CITY OF ALBUQUERQUE

April 10, 2025

RE: Tierra Linda Apartments
99999 98th Street SW
Conceptual Grading & Drainage Plan
Engineer's Stamp Date: 4/8/25
Hydrology File: P09D004

Based upon the information provided in your submittal received 04/08/2025, the Grading & Drainage Plan is not approved for Building Permit. Please address the following items:

| XXXX.XX                 | P-09-Z        | C1.3        |             |

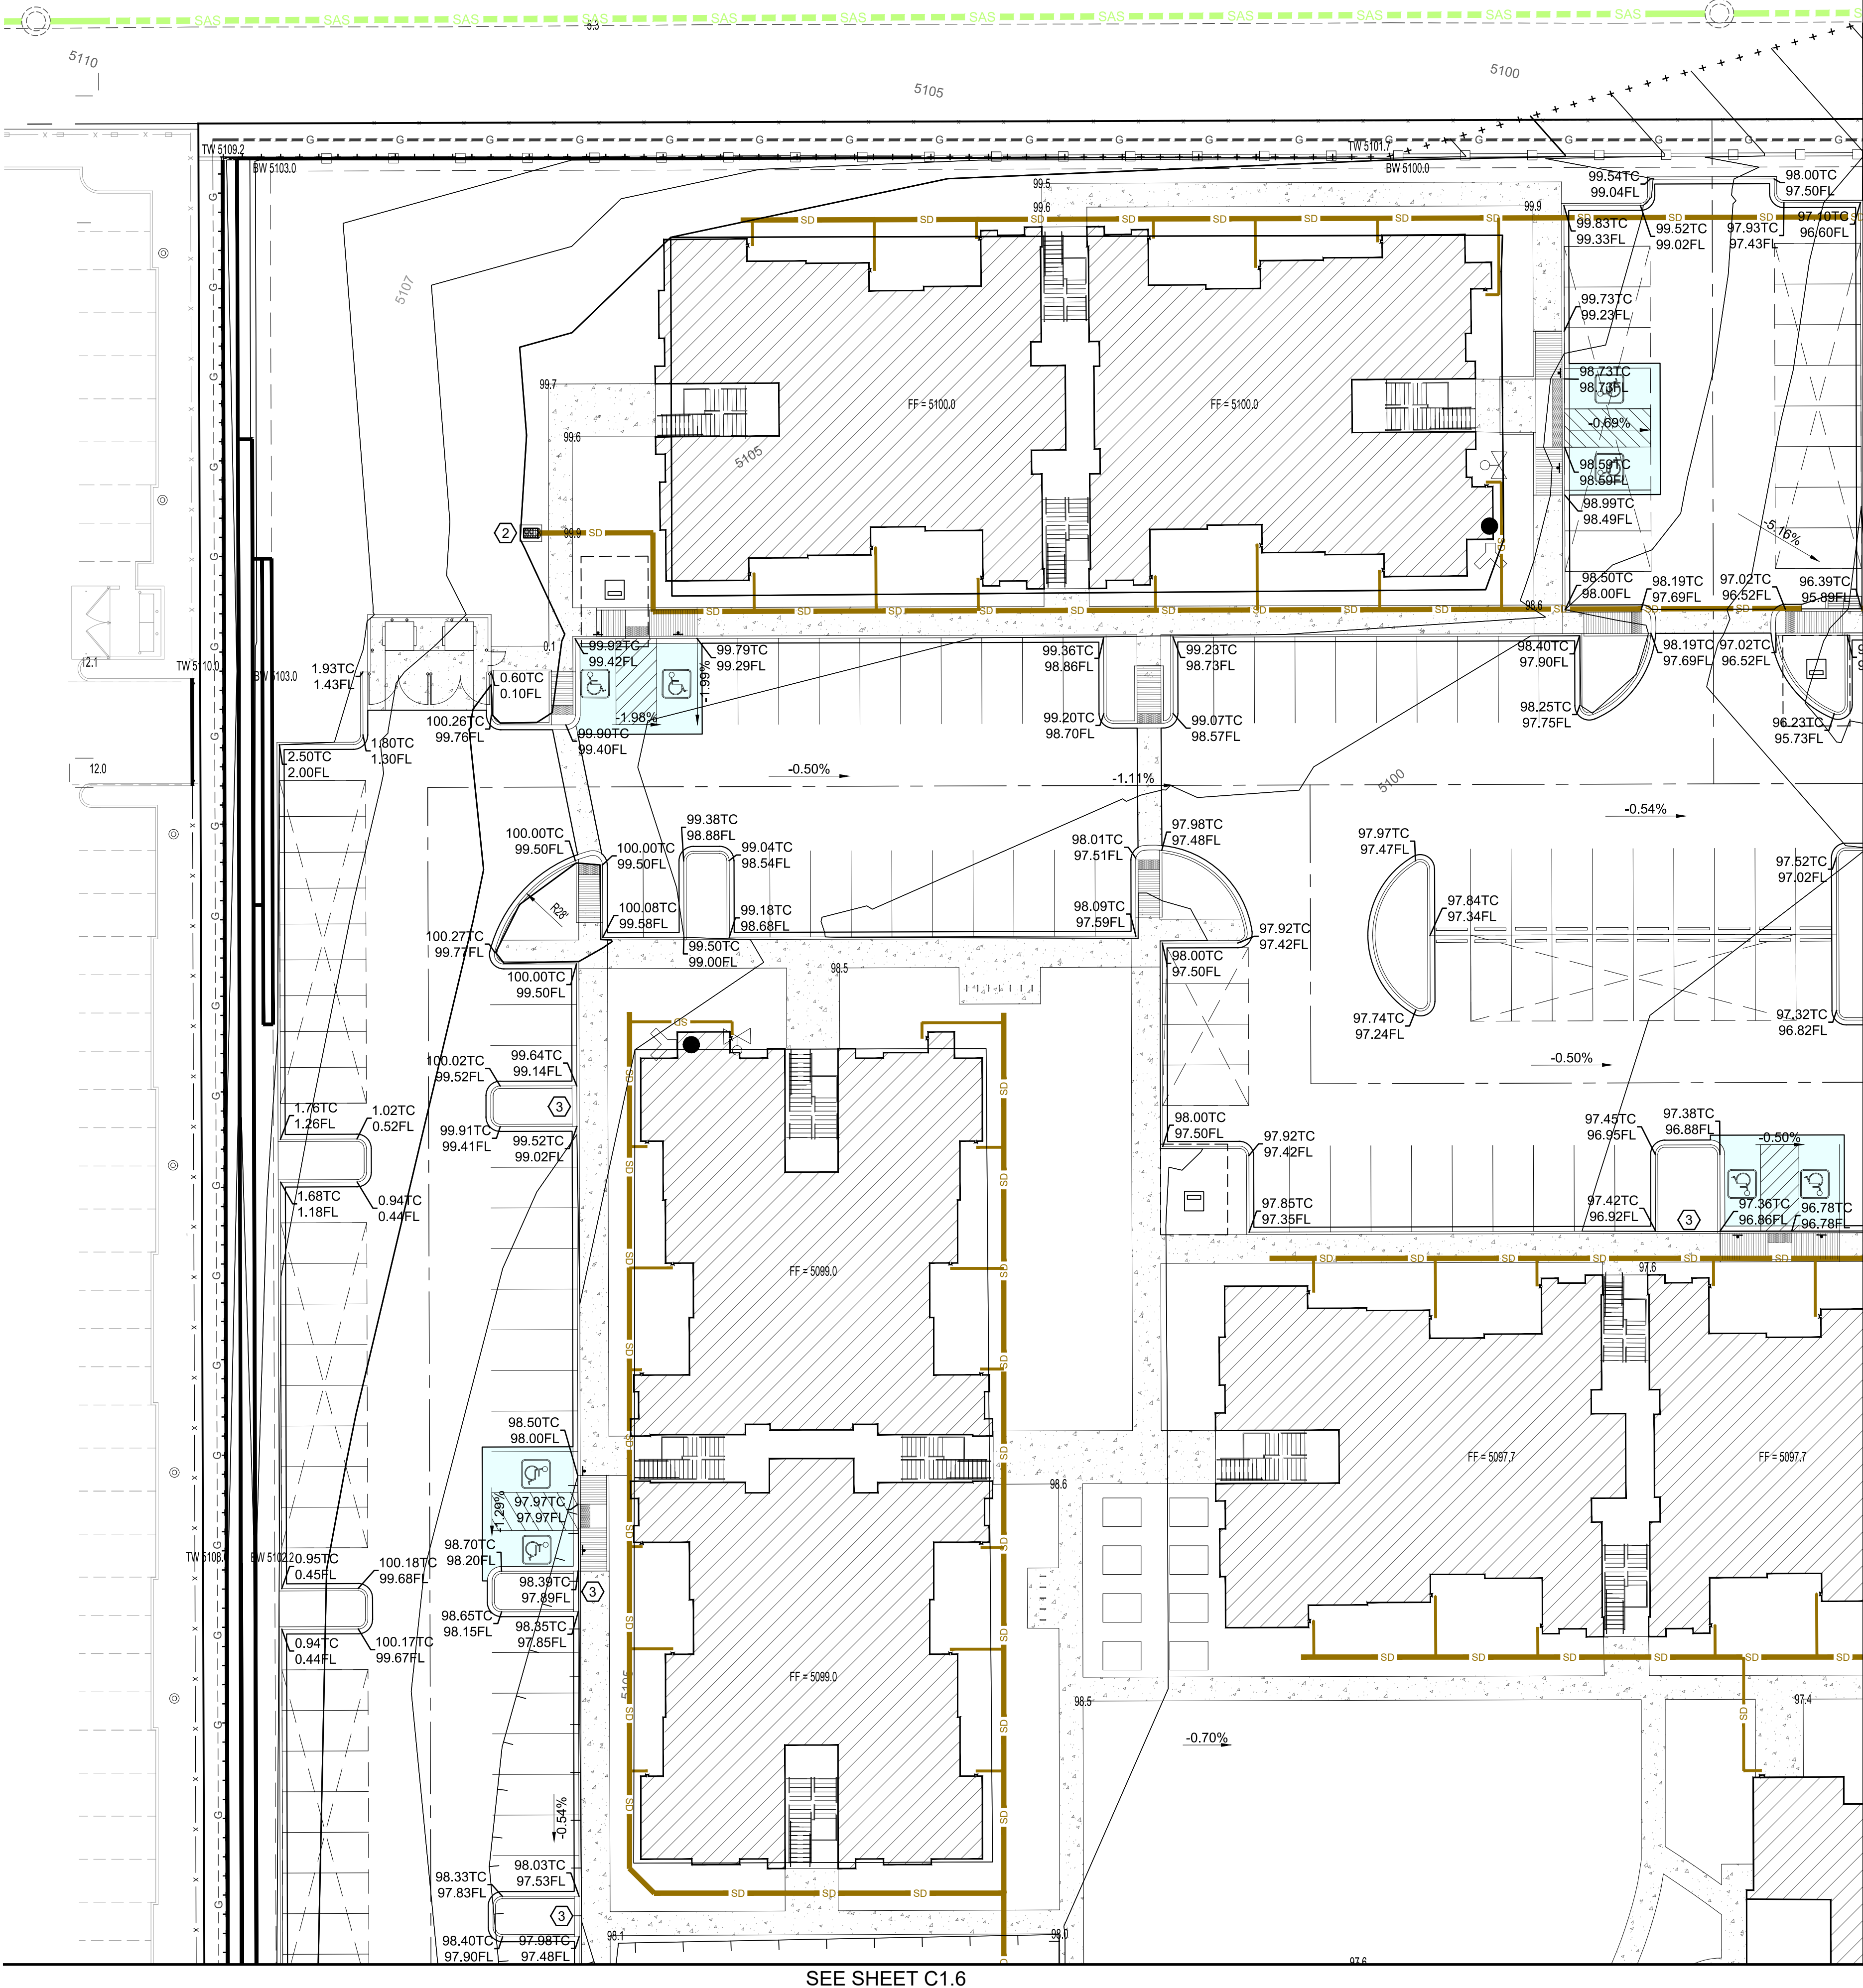
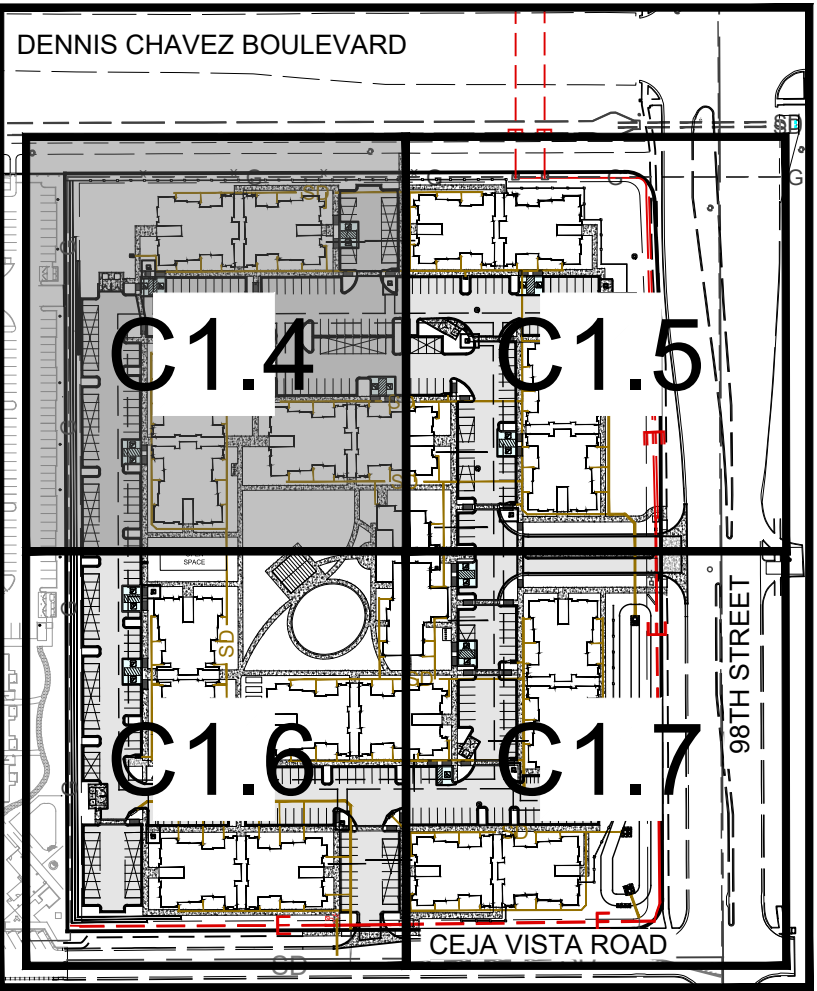
5. Please provide the legal description of the property.
6. Please number the ponds and include a label on each with the SWQV and elevation, the 100-year volume and elevation, the peak 100 year inflow and outflow, the spillway crest elevation, the spillway flow depth, and the dam top elevation.

8. Please provide more detail on the pond inlets and outlet. If rock rip-rap will be used for stabilization, please show in the plan.
